Subject: Tudor Close Public House Ferringham Lane Ferring BN12 5NQ - FG/86/21/DOC

Planning Application reference: FG/86/21/DOC

Proposal: Approval of details reserved by condition imposed under ref FG/105/20/PL relating to Condition Nos 3 - car parking, 4 - materials & finishes, 5 - covered & secure cycle parking spaces, 6 - Arboricultural Impact Assessment, 8 - decentralised, renewable & low carbon energy and 9 - charging of electric vehicles.

1:200 PROPOSED
ARUN DISTRICT COUNCIL FG/86/21/DOC

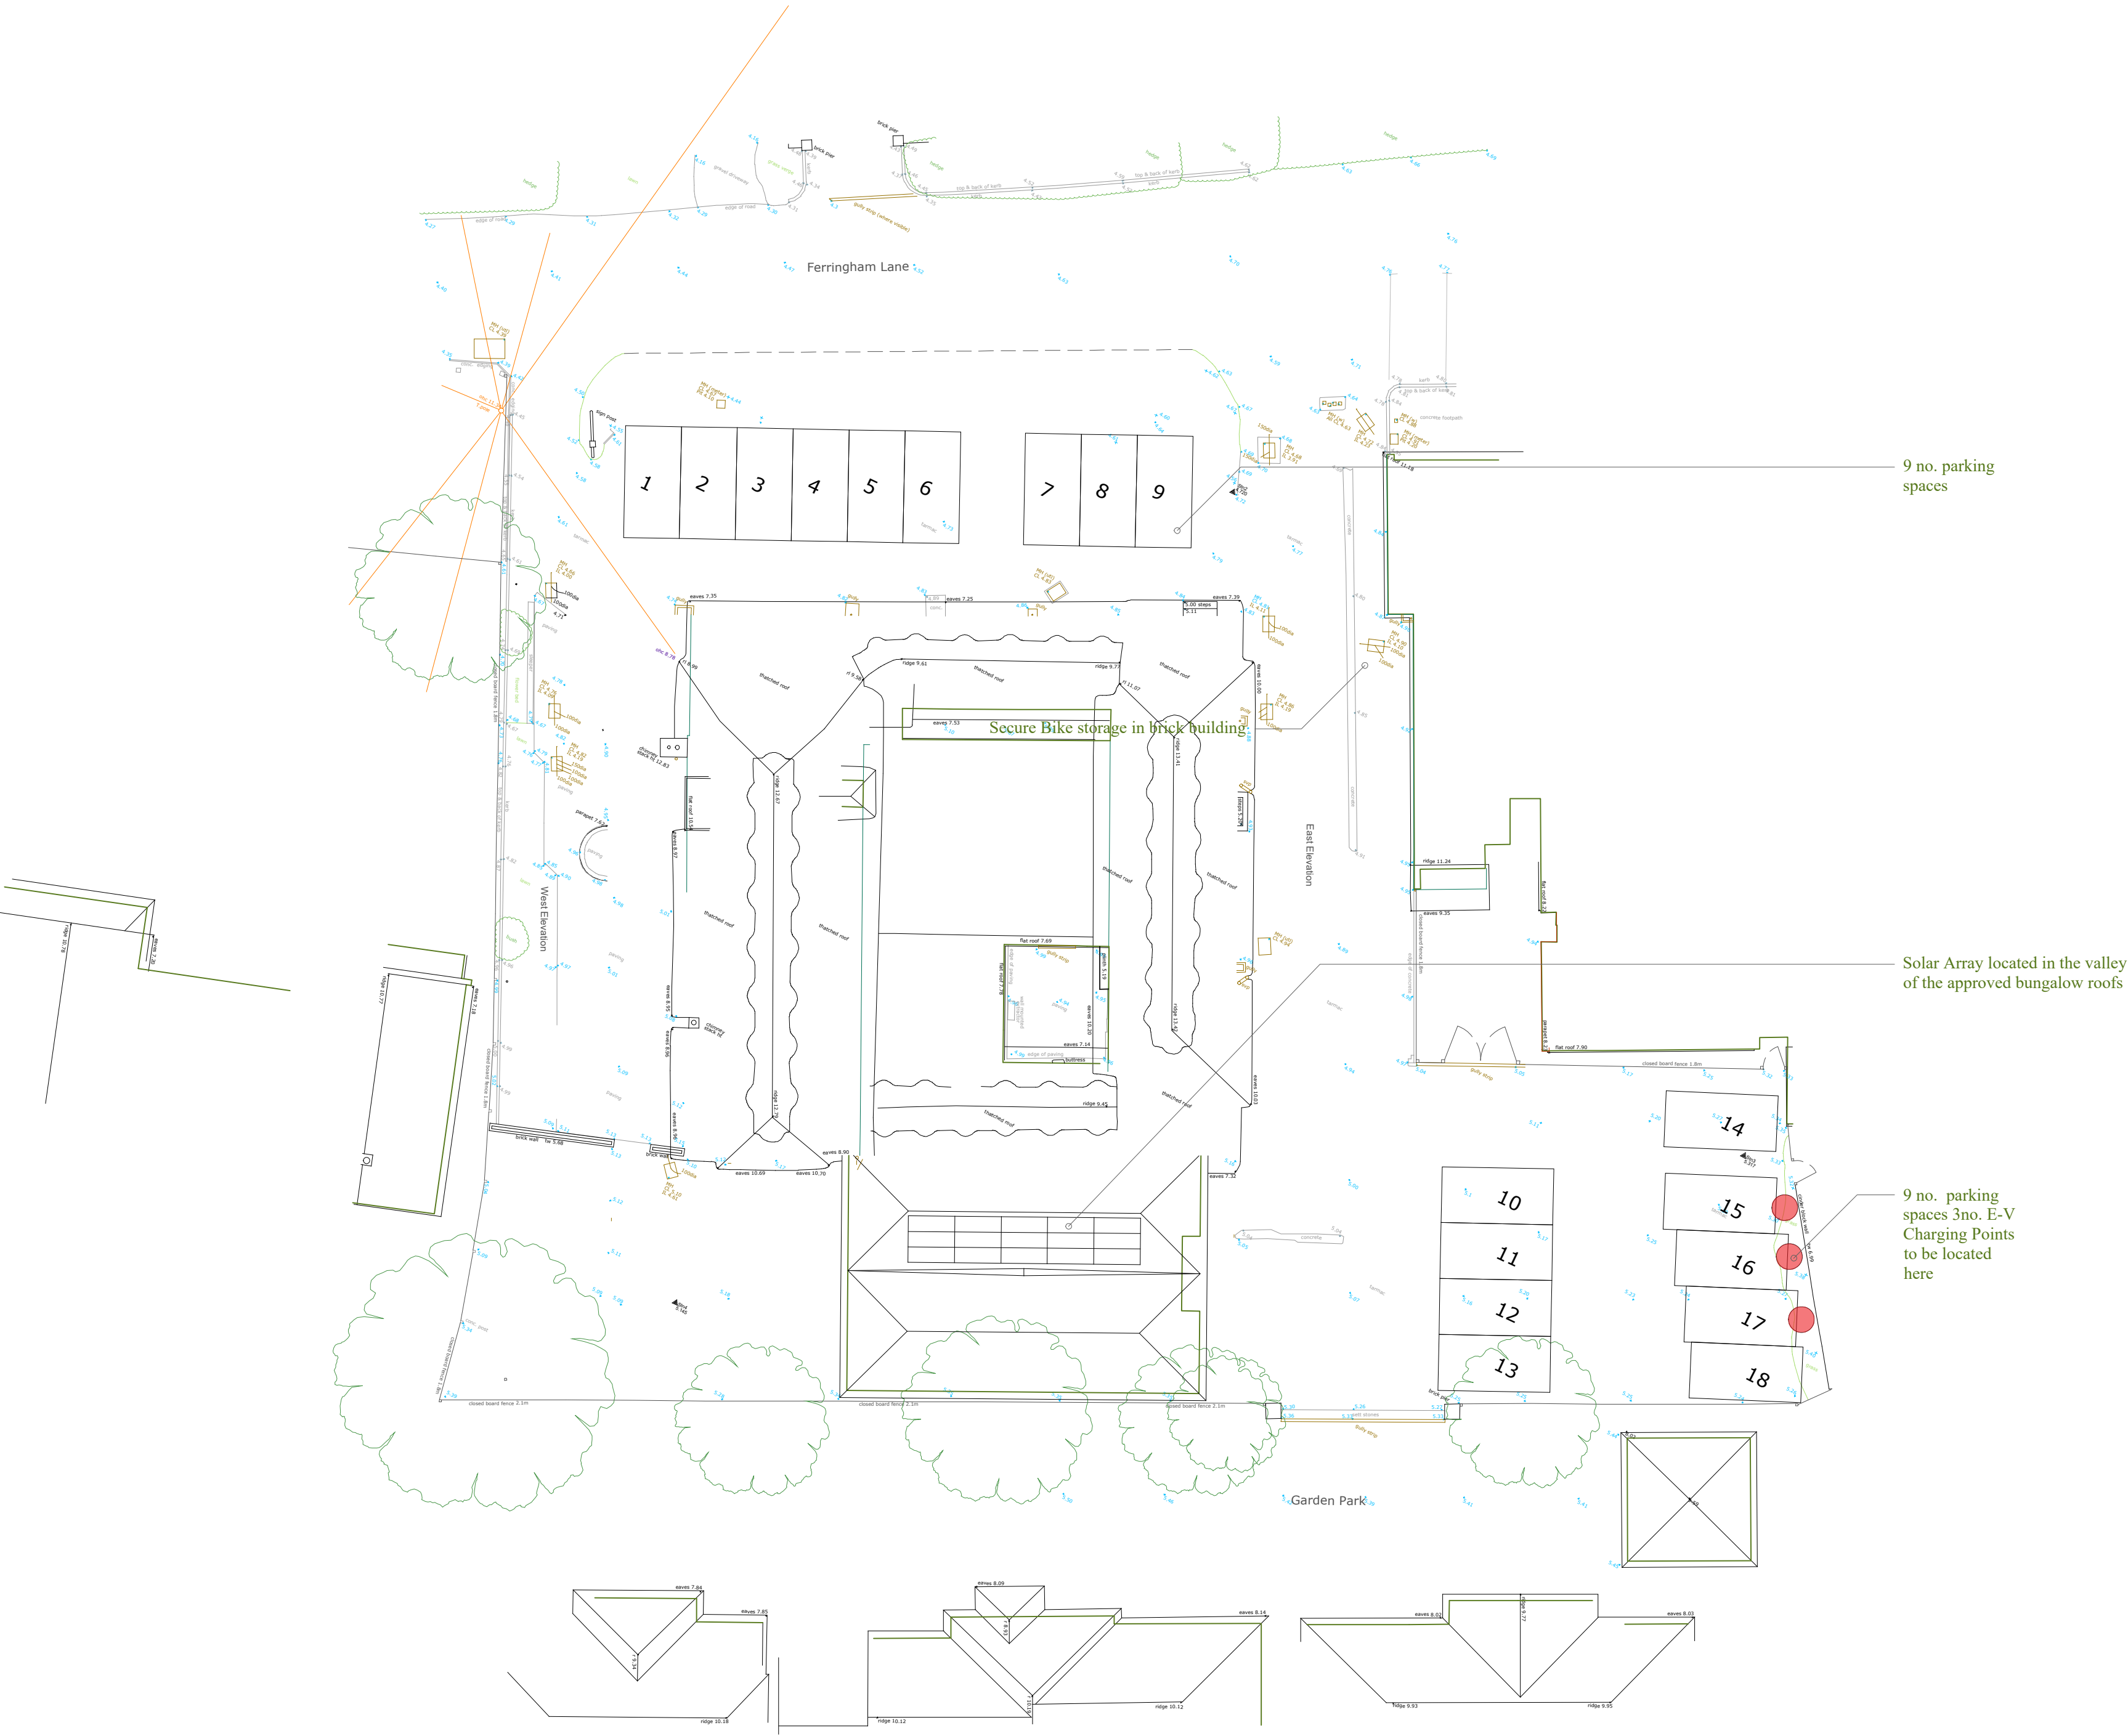
I can confirm that the proposed EV charging point is included in the governments EVHS approved charge point model list. However, the HM Government document entitled 'Electric Vehicle Charging in Residential and Non-Residential Buildings' requires that an EV charging point is installed in every dedicated car parking space when new dwellings are constructed.

The applicant has proposed to install 3 EVCP's and proposes 9 new residential dwelling units. I therefore request that the applicant install 1No. electric vehicle charging point for each dwelling, or demonstrate / justify that this is not economically feasible due to lack of infrastructure from the national grid at the proposed development site
